Wheatfield Cottage
22 Smithy Place
Brockholes
Holmfirth
HD9 7AH

15/02/2022

Objection to Planning application 2021/62/92206/W

**Figure 3.1: 2km Walking Catchment**

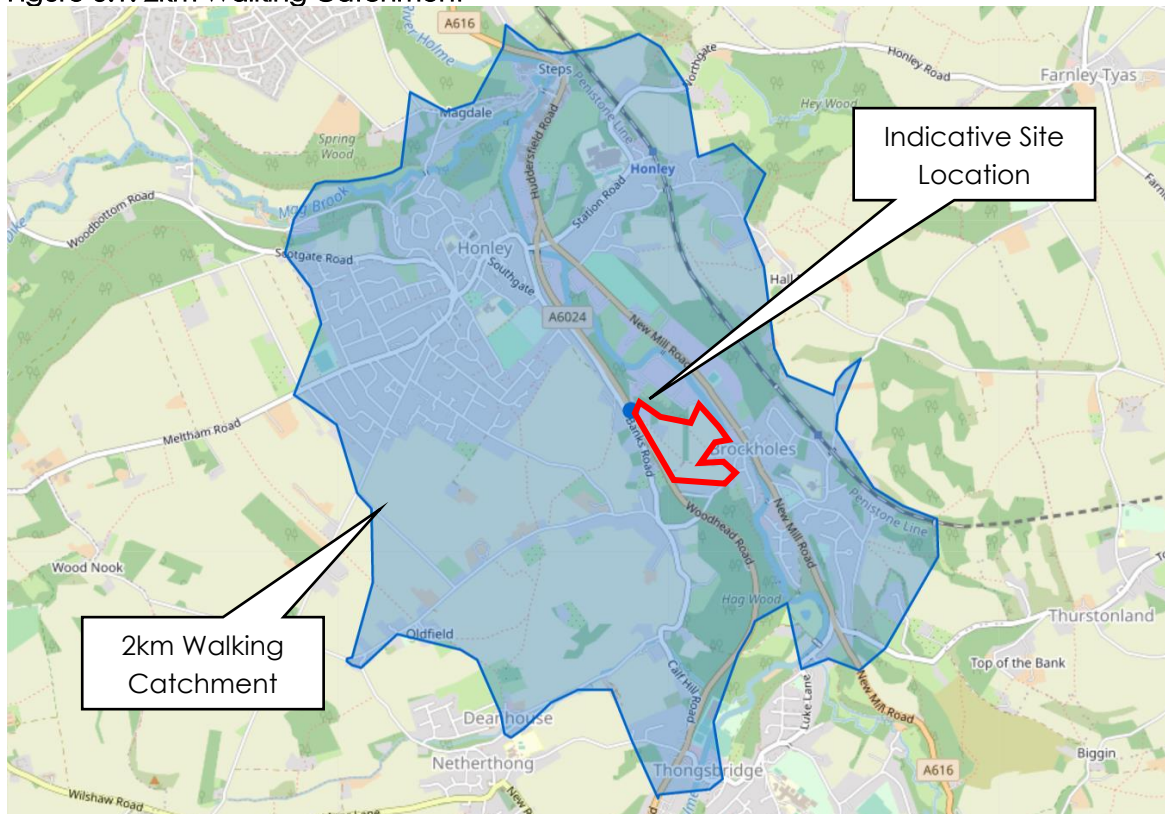
The suggestion that all routes are safe is untrue, pedestrian links to Brockholes are along unadopted, unlit paths or narrow sections of road on which there is no footpath. Pedestrian access to Honley is similarly unsafe, a significant section of the footpath on Woodhead Road is unlit by streetlights and the two sections of Far End Lane which link it to Woodhead Road are without pavement.
